Application by Highways England for A63 Castle Street Improvement-Hull

The Examining Authority's written questions and requests for information (ExQ1)

Issued on 1 April 2019

3.1.1 Replace ES Volume 2 Figure 10.2 Non-statutory designated sites (APP-036) with the new Figure 10.2 Non-statutory designated sites as below. Changes are as follows:

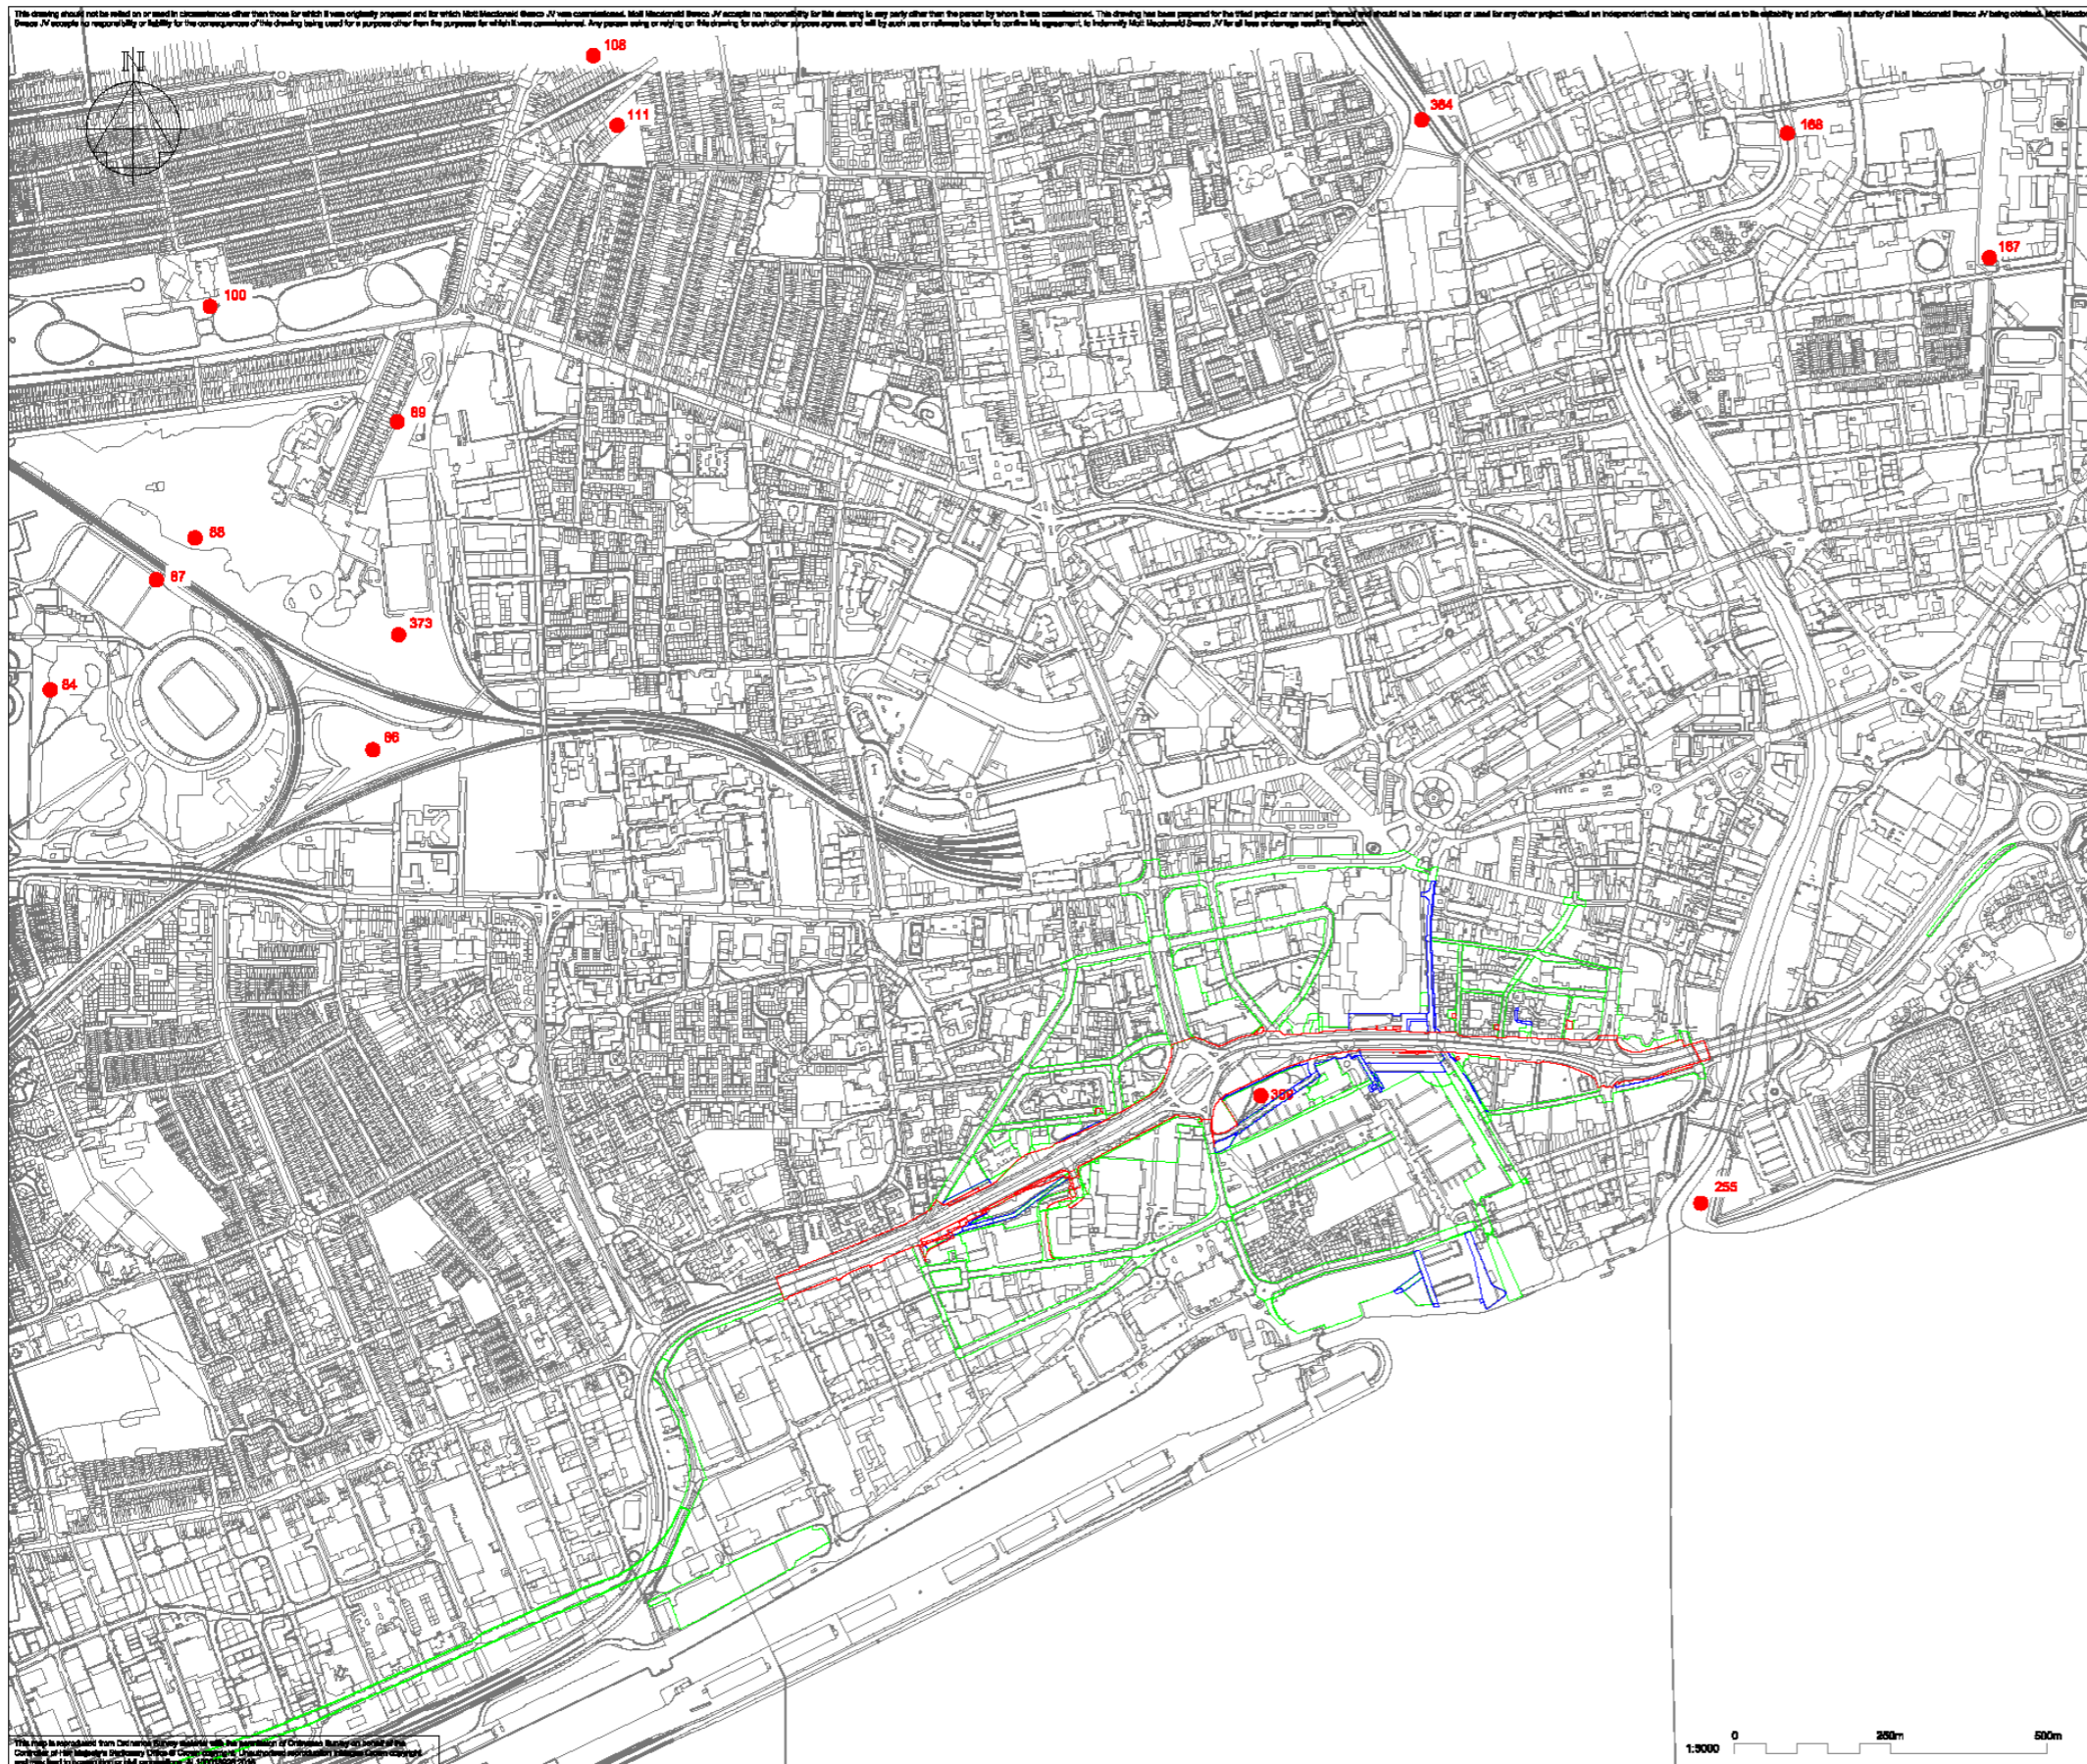
1.2.2.	Applicant	Non-statutory Sites The key on the Environmental Statement Figure 10.2 (non-statutory designated site) is incorrect, as already mentioned within the S56 advice. Please provide a new Figure 10.2 to address the issues identified at acceptance.

ExQ1	Question to:	Question:
	Applicant	<p>Non-Statutory Sites Not all non-statutory sites located within 2Km of the Proposed Development have been included in the assessment. For example, the mudflats to the south of Sammy's point is discounted but it is located only 250m from the Proposed Development. Please explain the rational for this.</p>
